Our ref: NE/2011/111405/05-L01
Your ref: N6/2010/3120/DC3
Date: 7 January 2013

Splashlands, Stanborough Road, Welwyn Garden City.

Thank you for consulting us on the revised Flood Risk Assessment.

FLOOD COMPENSATORY STORAGE CROSS SECTIONS

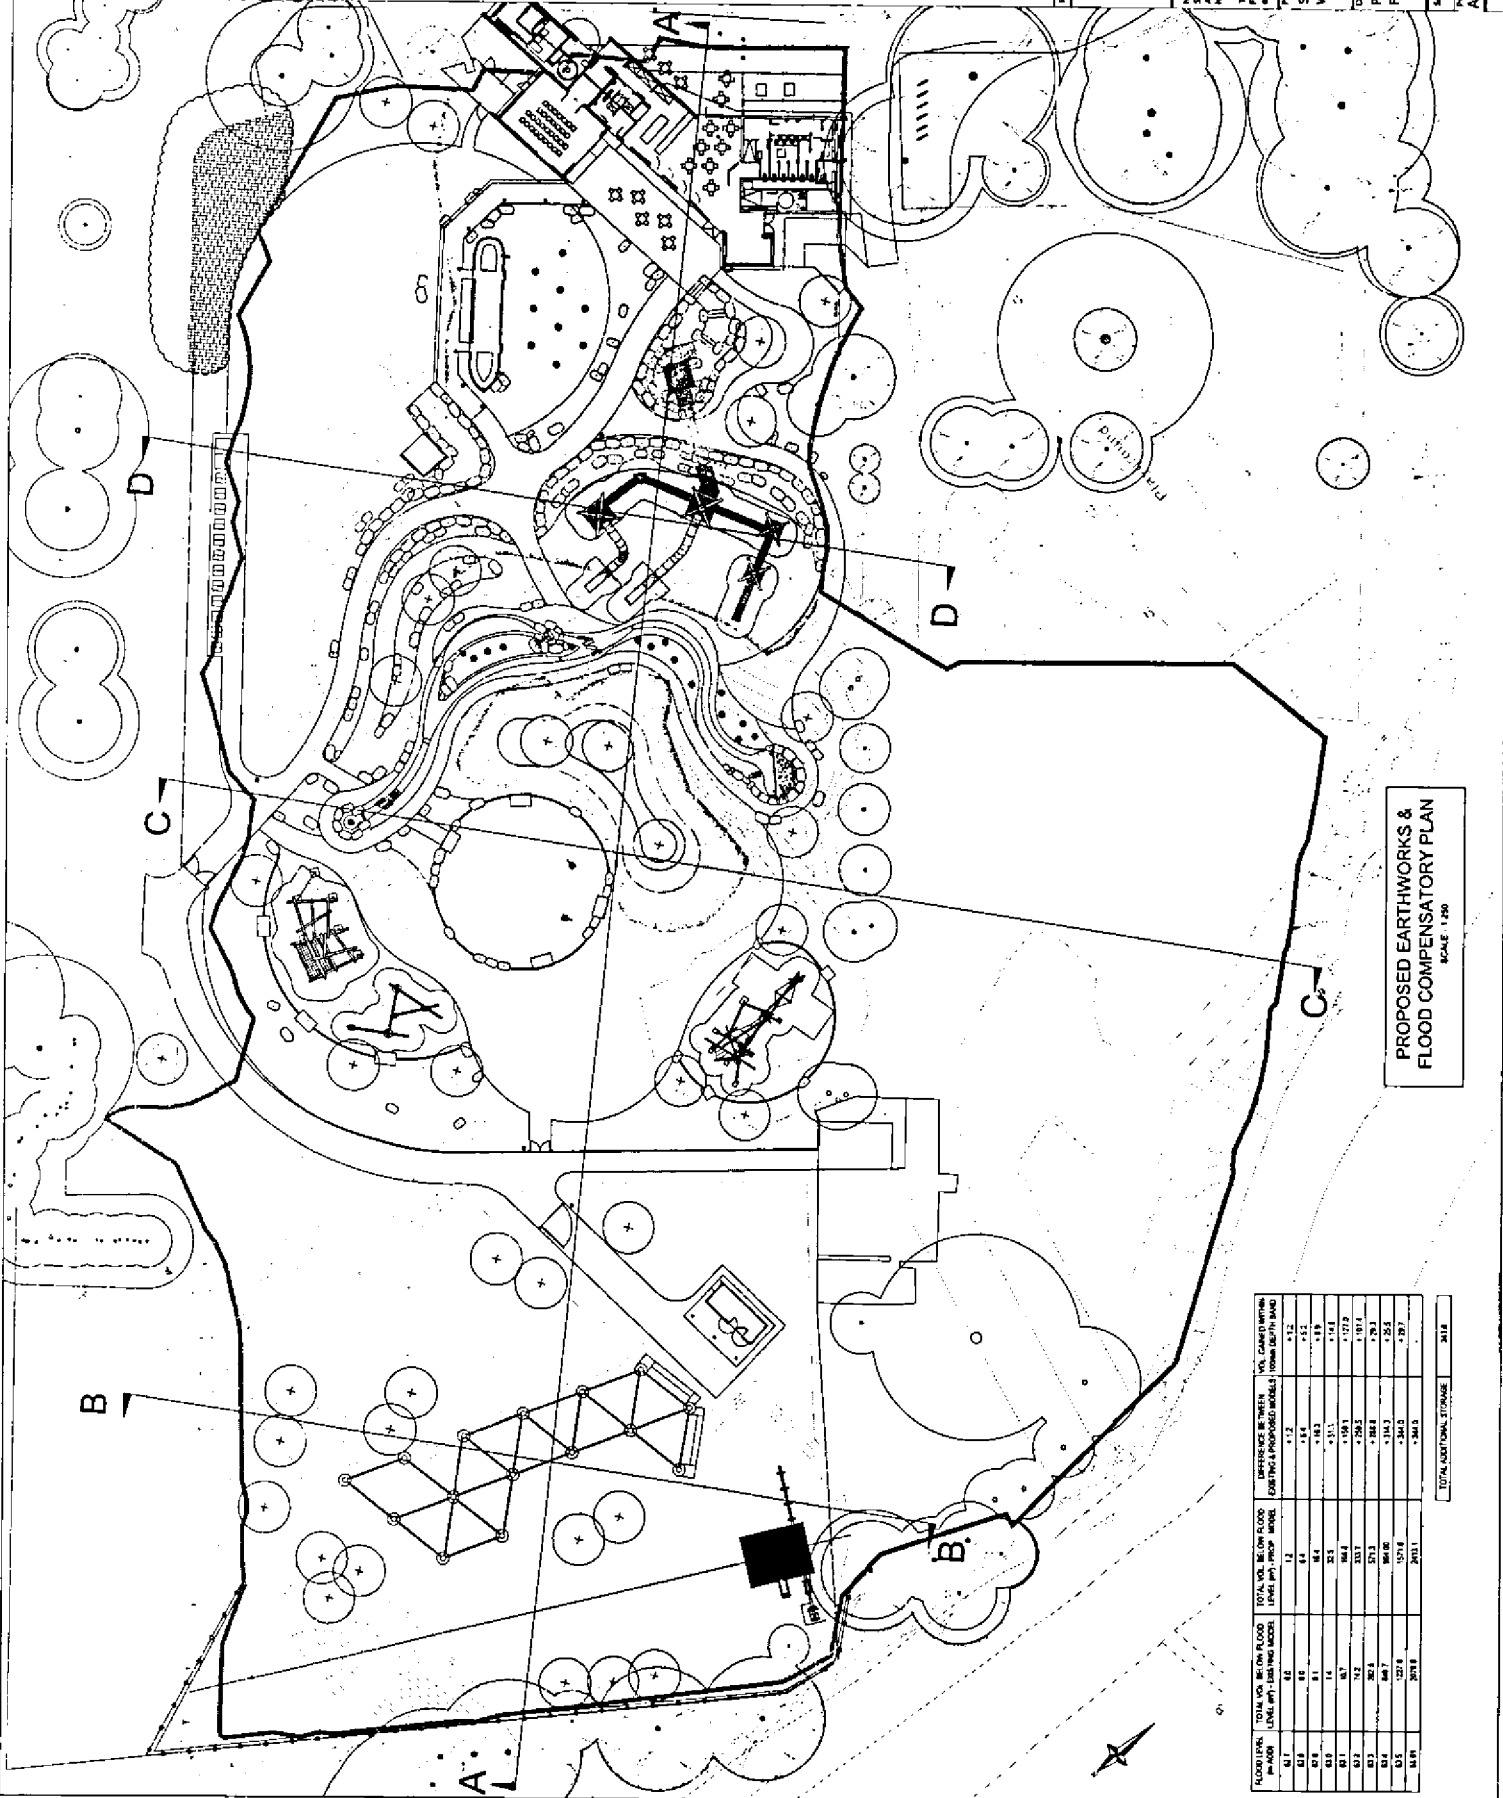
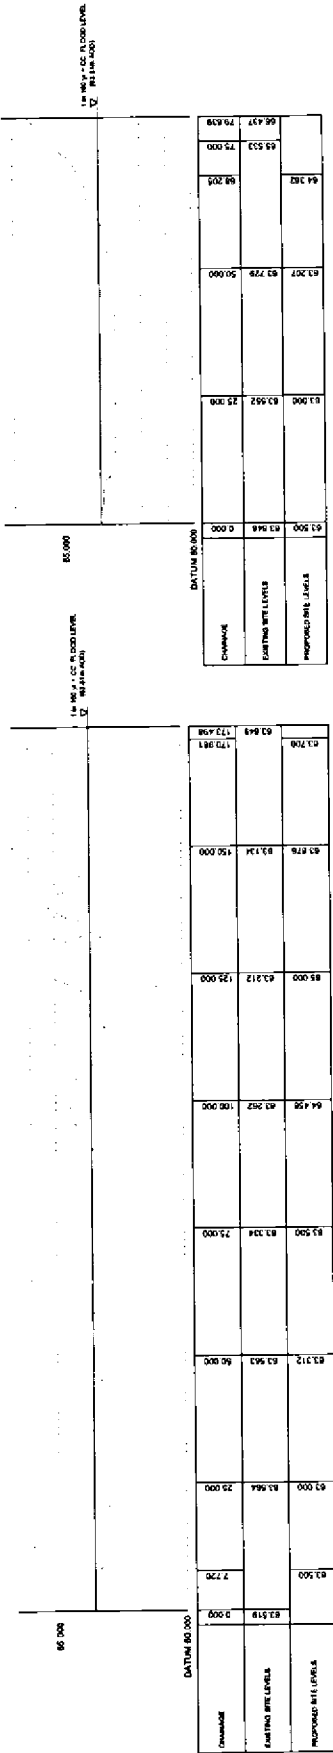
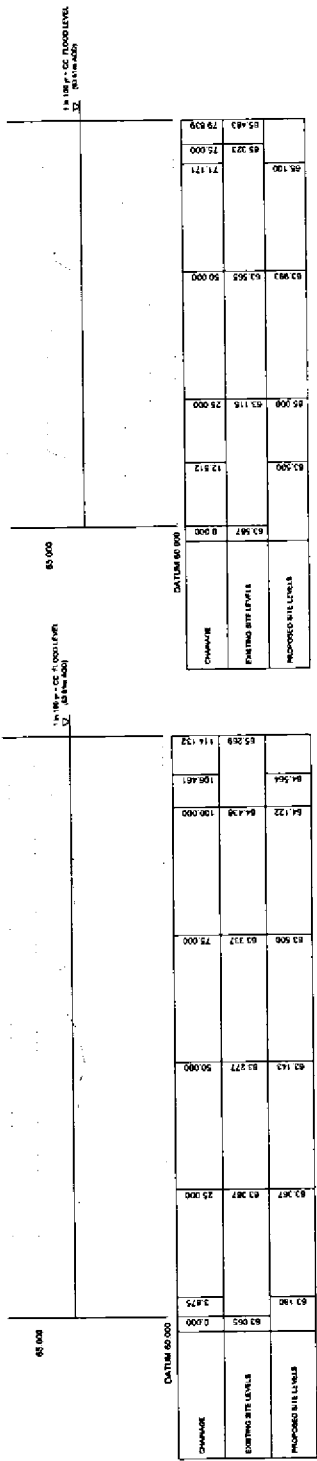
- Compensatory flood storage on the site to a 1 in 100 year plus climate change standard is to be provided during phase 2 of the development based on the details shown on drawing A067207-5-10B, which provides an indication of the required floodplain storage under phase 2, and drawings A067207-5-122 & 123 which show proposed earthworks to achieve the required floodplain storage following development.
- Finished floor levels are set no lower than 63.91m above Ordnance Datum.
